**Objection to SSD application for the development of the Berrima Jail.
SSD - 66876472**

I live in Berrima, on the opposite side of the river from the jail. I strongly object to the (over) development of the Berrima Correctional Facility site.

1 West Elevation_Wingecarribee River
1:250

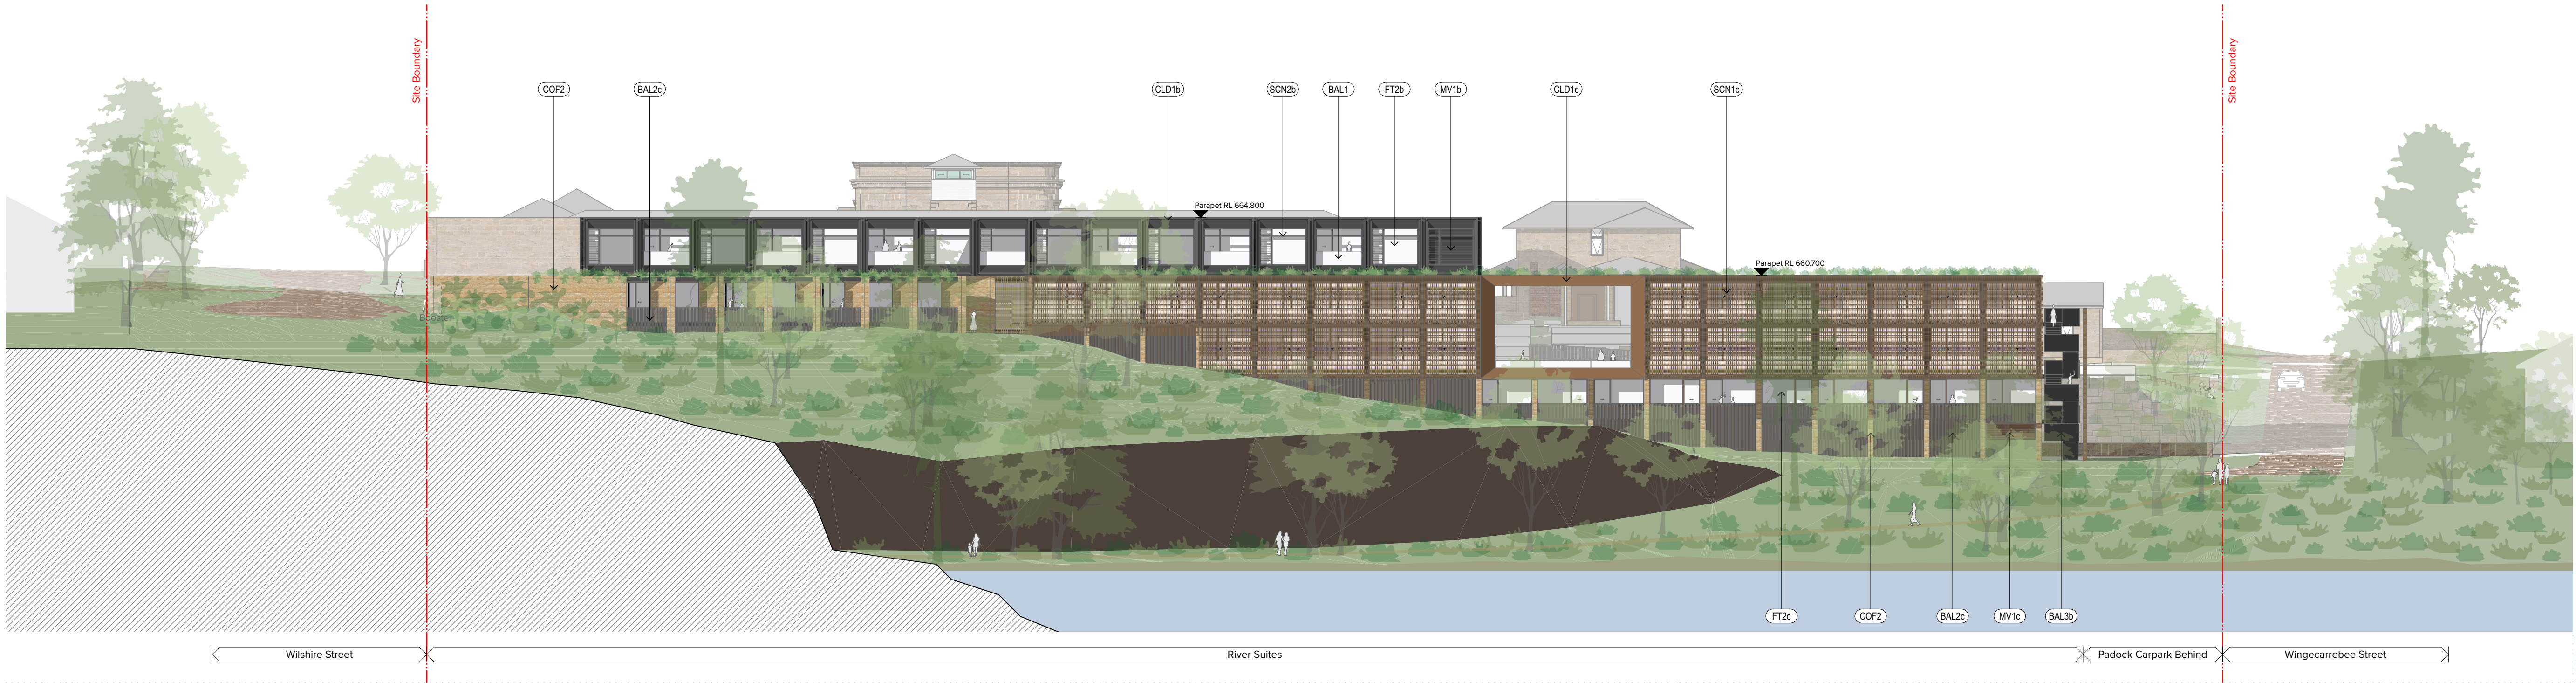
The proposal trumpets about the heritage value of the exterior walls of the jail. It boasts about the development's proposed restoration of the exterior walls. But then it proposes to completely block the Western Wall from view with a huge hotel in a "bar form" structure. (Appendix 6 – pages 157-159, 236)

The huge hotel structure containing 55 guest rooms will become the feature of our view. It will contain lighting at night, making the effect worse. Conversely, many of the rooms will have a view into our living and dining rooms. That is an outrageous proposal when currently we do not have an outlook into any built structure.

The extent of the proposed hotel structure is underplayed throughout most of the application. In fact, it is approximately twice as wide as the jail itself, being constructed across the entire western boundary of the land. The mass of the hotel structure only becomes apparent at page 86 of APPENDIX 6 – the Architectural Design Report. It is huge. It's the same height as the jail walls, meaning of course that the jail wall will be entirely masked by the new building.
